D-49 Transportation Center
Traffic Impact Study
(LSC #S214340)
PCD File No. U-221
May 9, 2022

Summary of Comments on Signed TIS_v2.pdf

LSC Responses to TIS Redline Comments.

Figure 2
Proposed Site and Access Plan

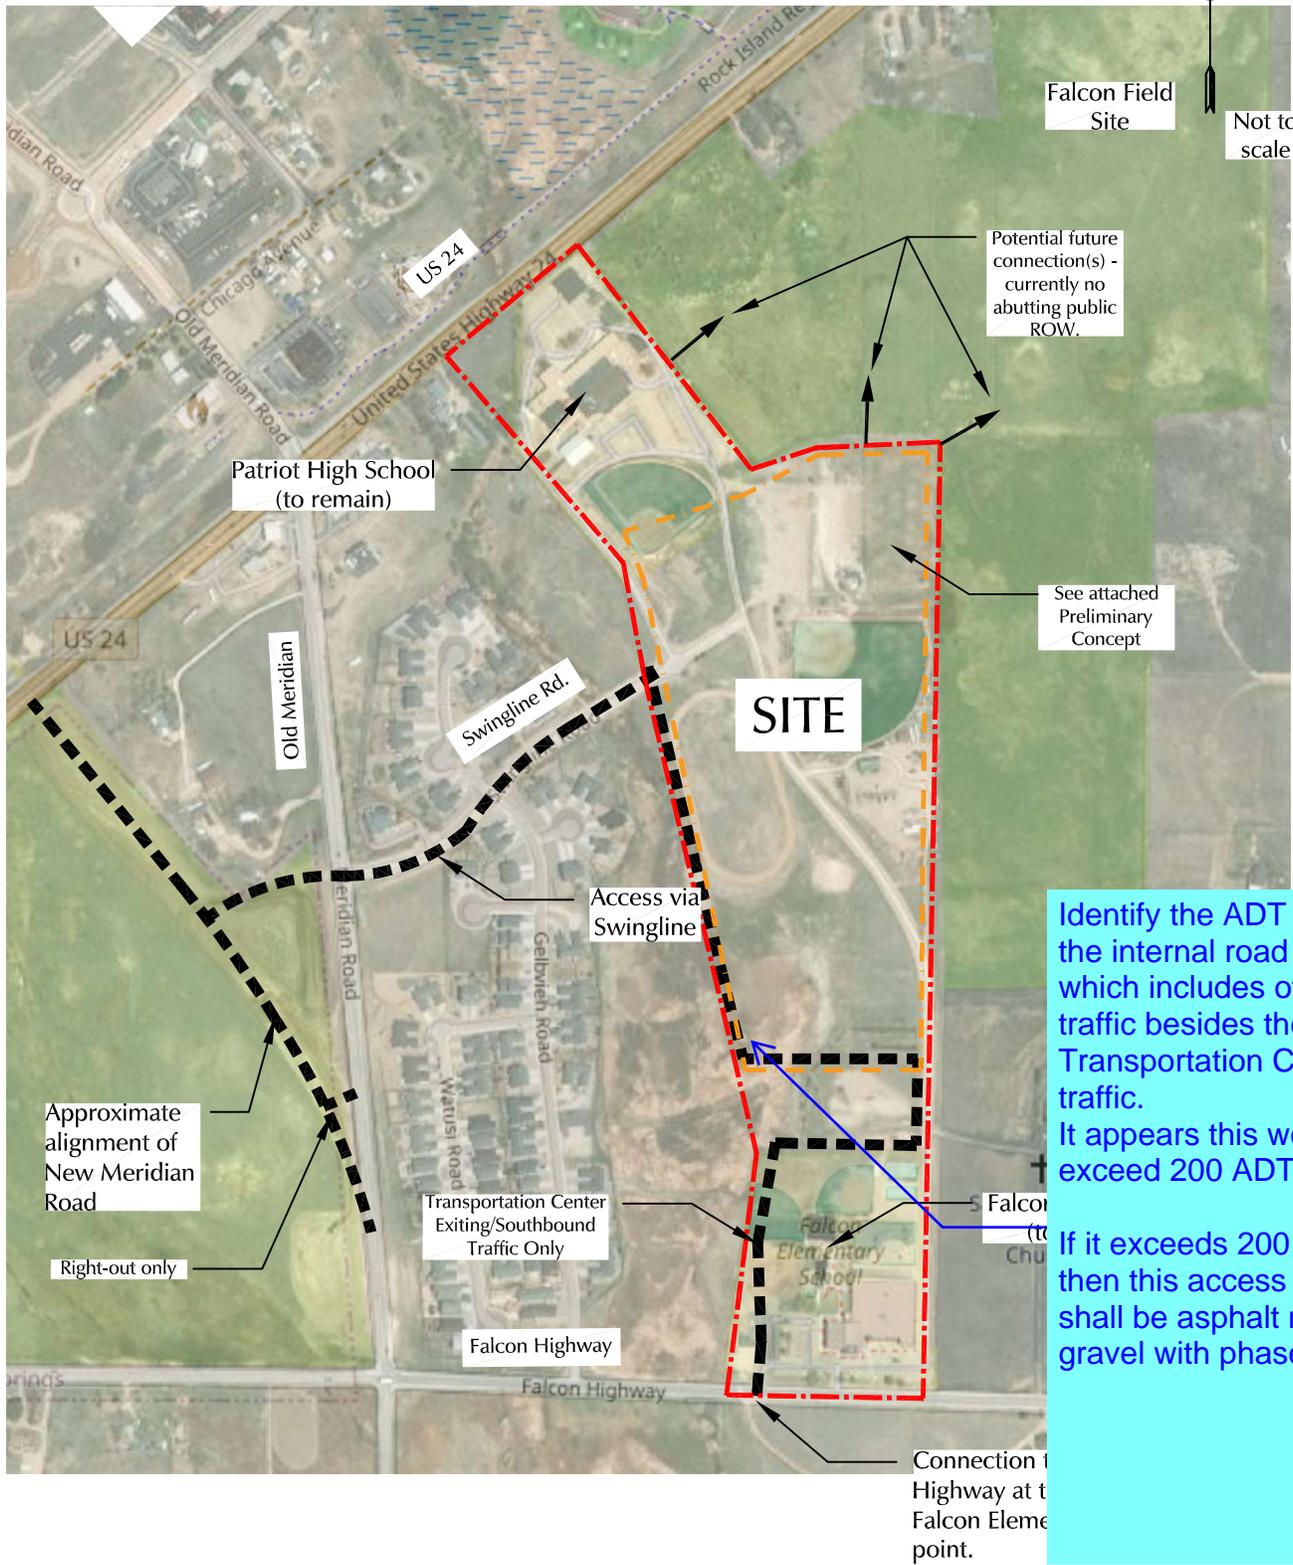
Identify the ADT of the internal road which includes other traffic besides the Transportation Center traffic. It appears this would exceed 200 ADT. If it exceeds 200 ADT then this access road shall be asphalt not gravel with phase 1.

LSC Response: Additional ADT information has been provided in the updated TIS report. Regarding the paving of this internal road, the TIS has been updated to indicate the following:

"County staff has indicated a requirement to pave this roadway if over 200 vehicles per day ADT. Fall 2022 counts by district staff during Falcon Elementary peak periods of parent drop off and pick up indicated about 95 trips and 87 trips, respectively. The short-term additional ADT is projected to be about 150 vehicles per day generated by the transportation facility on the internal north/south roadway between the proposed transportation center and the elementary school. The total ADT would include trips currently generated by the elementary school. As this roadway is proposed to remain on school district property and will be maintained by the district. *The school district does recognize the benefit of paving to internal operations and to the neighborhood. For this reason, it is a high priority of the district to provide this feature when it is possible to do so. It is important to the district's long-range plans to begin construction of the Transportation Center now, however unfortunately, the funding is just not available to pave the project during the initial phase one construction.* With respect to dust mitigation, the district could potentially provide alternative dust mitigation measures to paving."
